Application no: 18/00459/DISC

Proposal: Discharge of condition 7 (Means of access to highway) 8 (internal access) 9 (driveways etc) of 14/02156/OUT

Location: Land South Of Cotefield Business Park Phase 2 Adj To Blossom Field Road Bodicote

Transport Development Control

Road 5  
Horiz. 1:500 Vert. 1:50

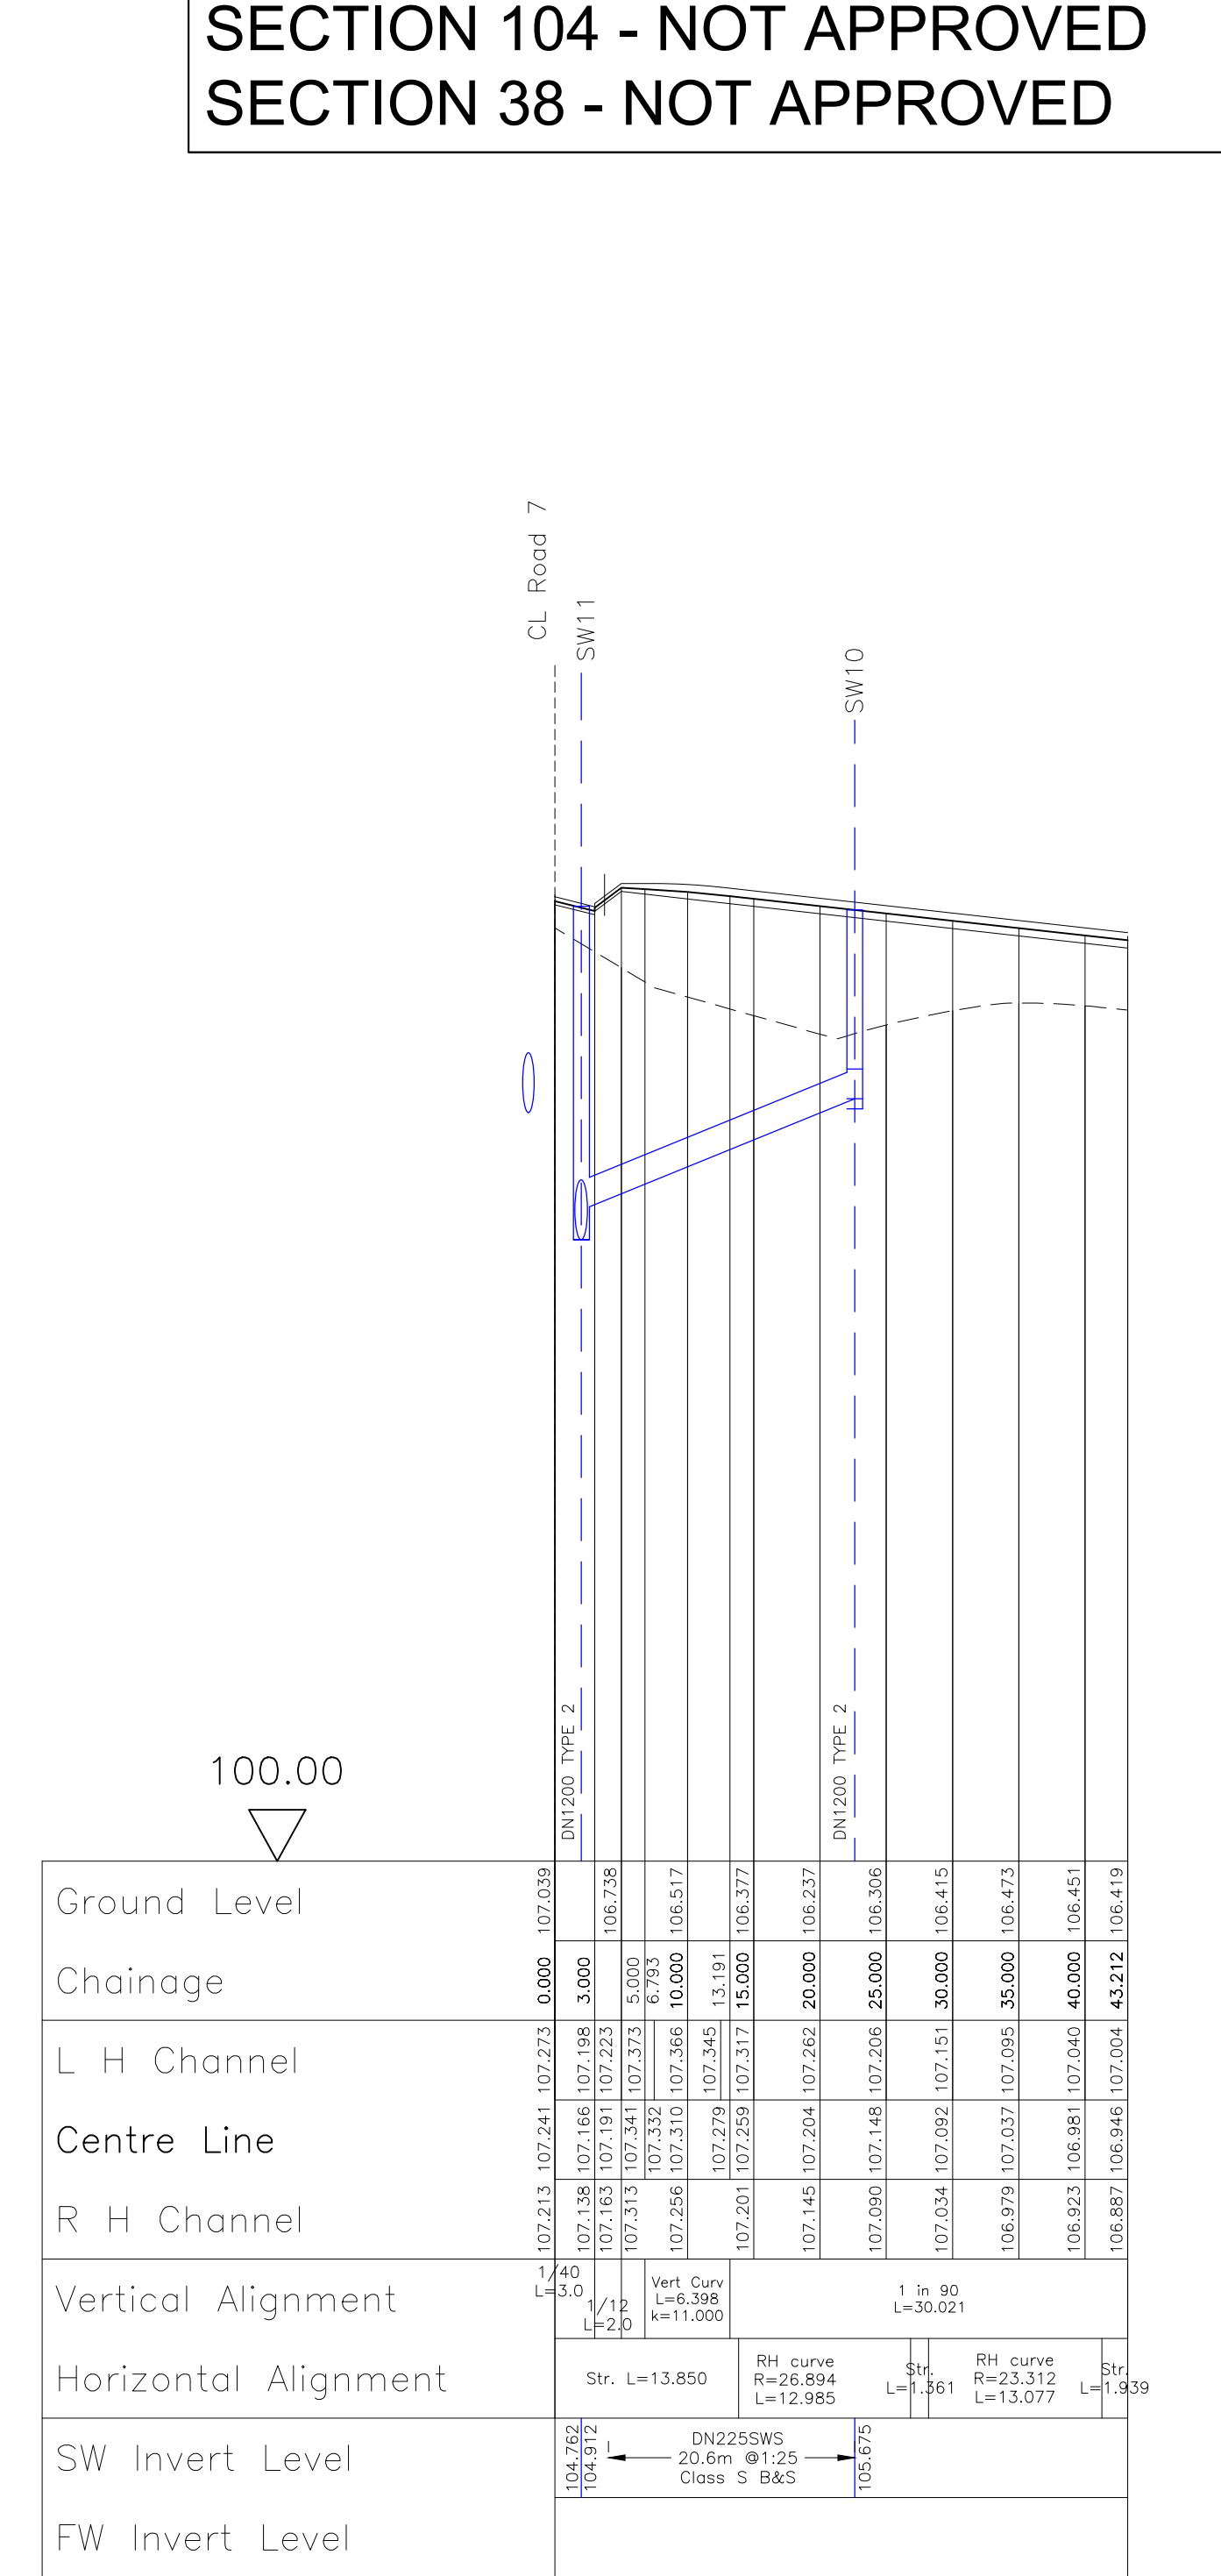
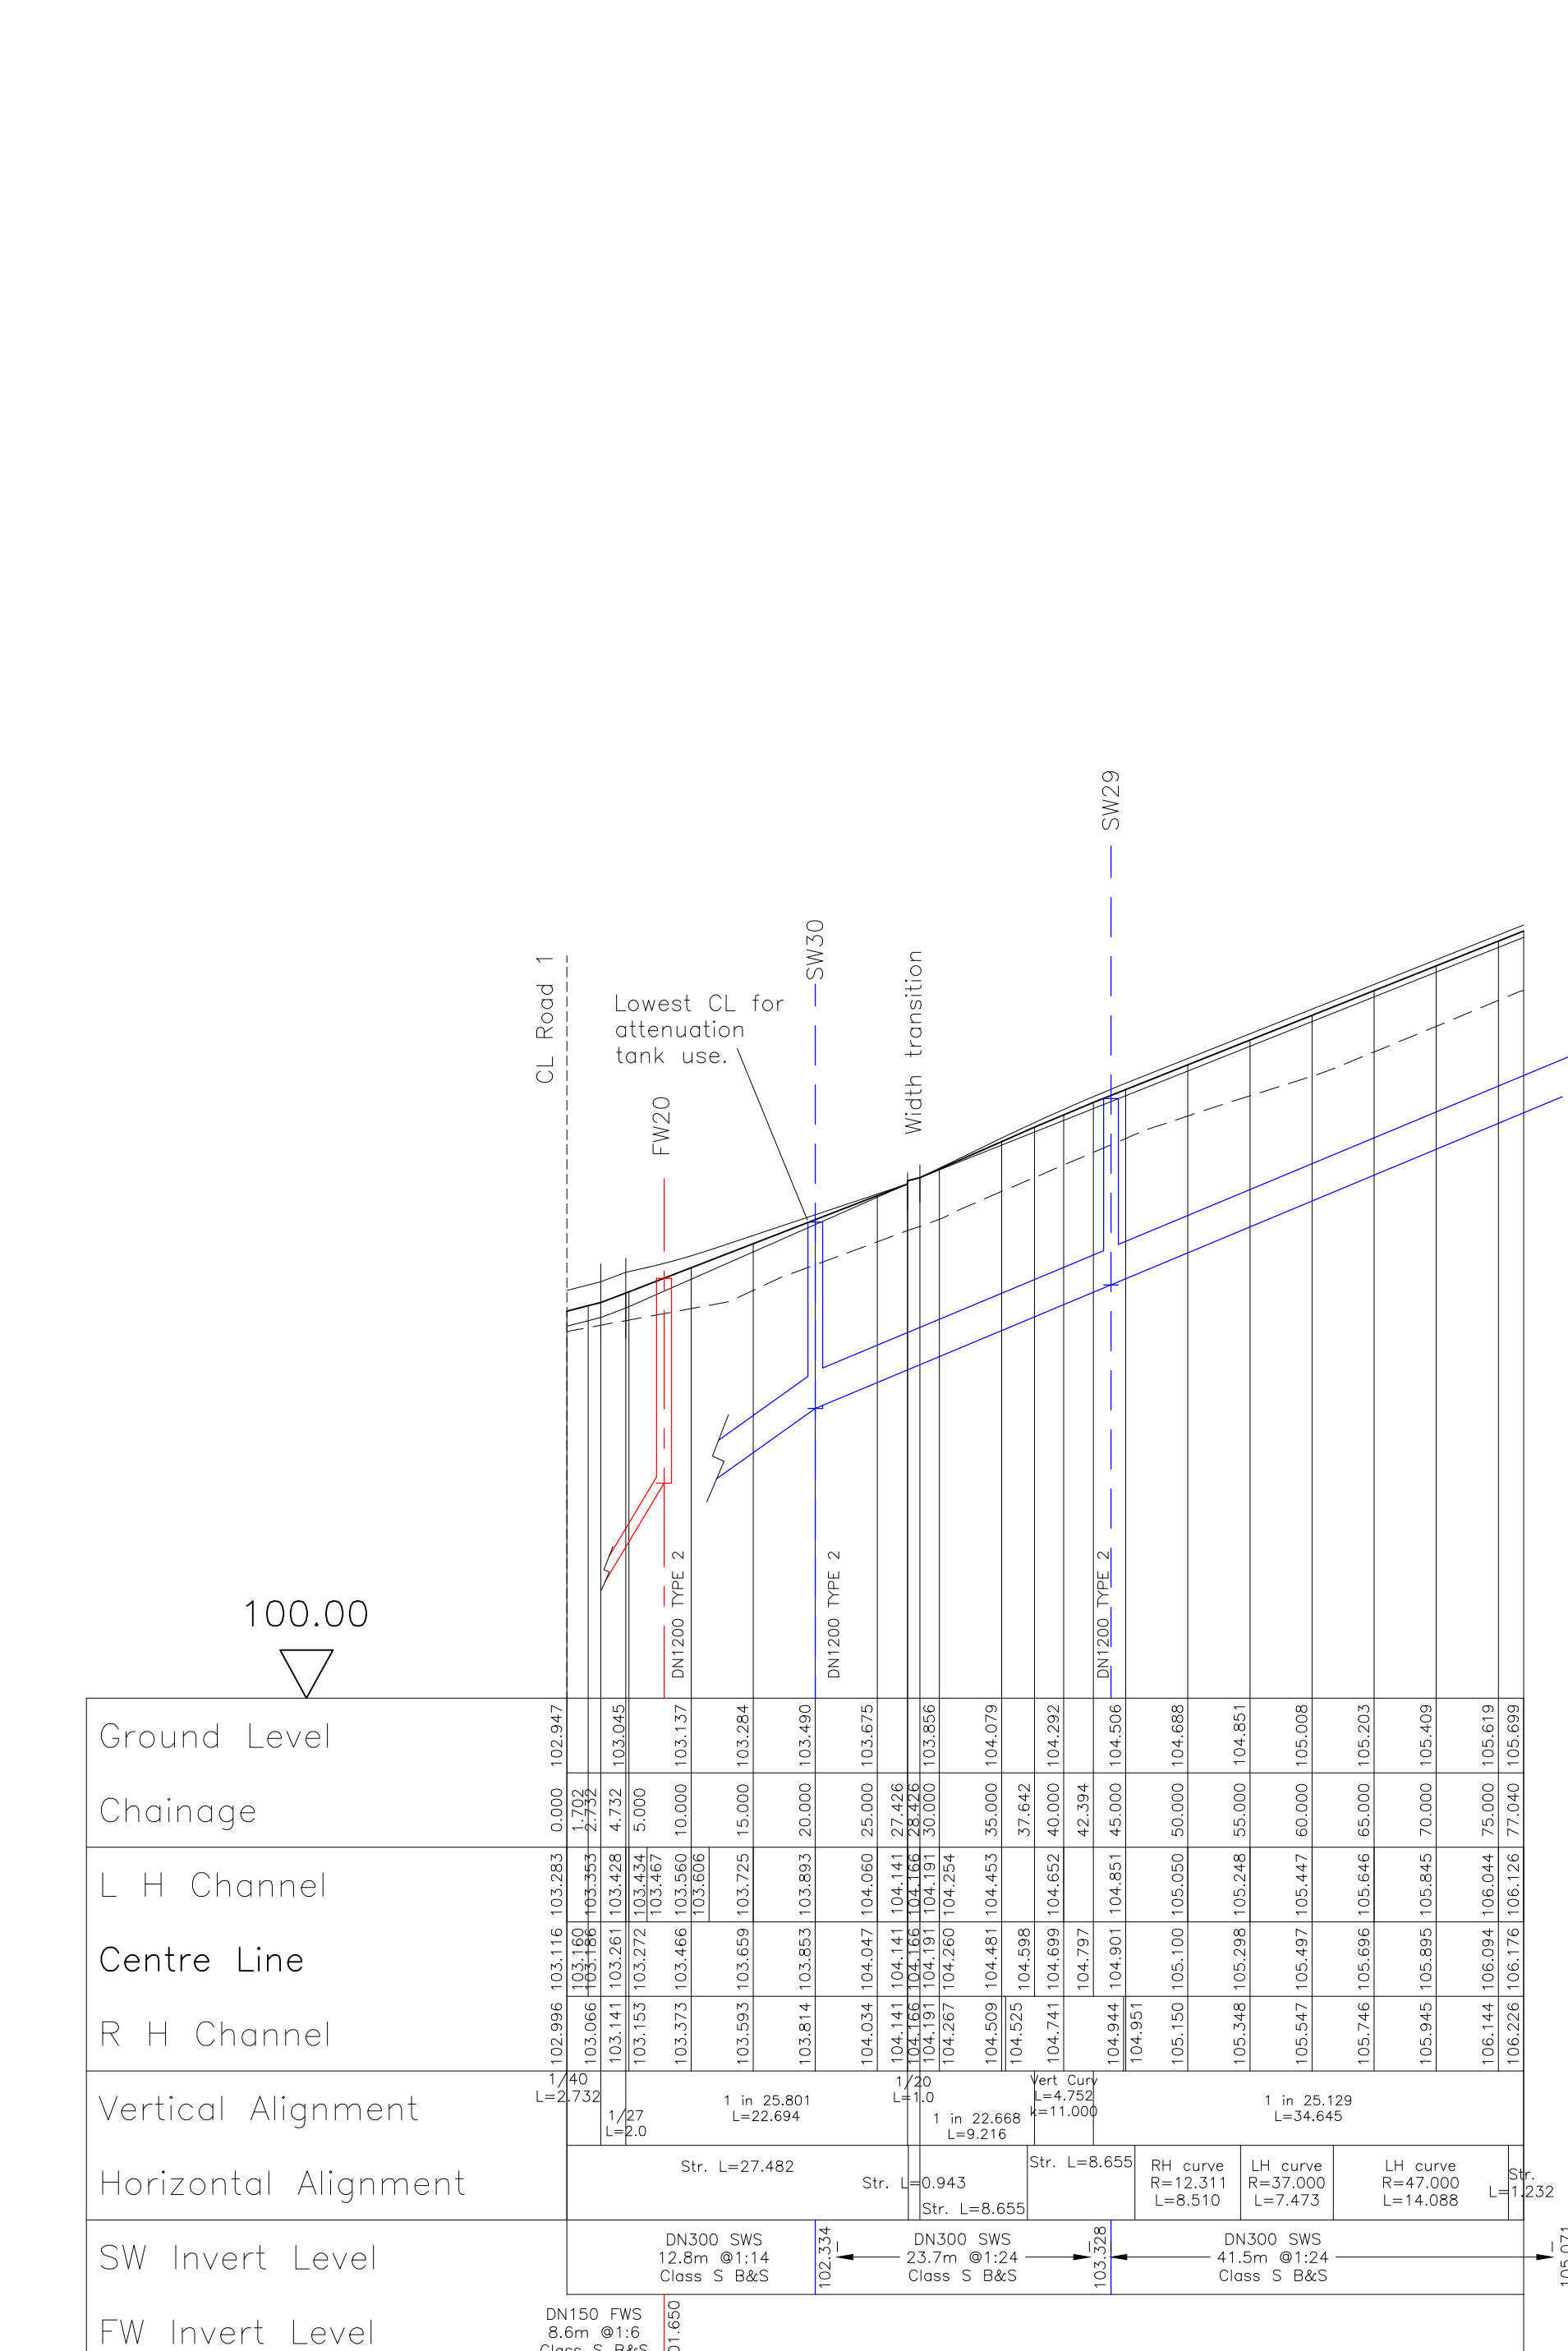
Condition 8 – Internal access – Objection, issues with ground levels.

However, the remaining conditions are a cause for concerns at present for Road Agreements due to the ground levels of the site and this is still currently being determined with them as to how these details can be resolved satisfactorily via the Section 38 audit process.

Please direct the applicant to liaise directly with OCC Road Agreements via the following email address - RoadAgreements@Oxfordshire.gov.uk in order to reach an agreement as how to proceed accordingly.
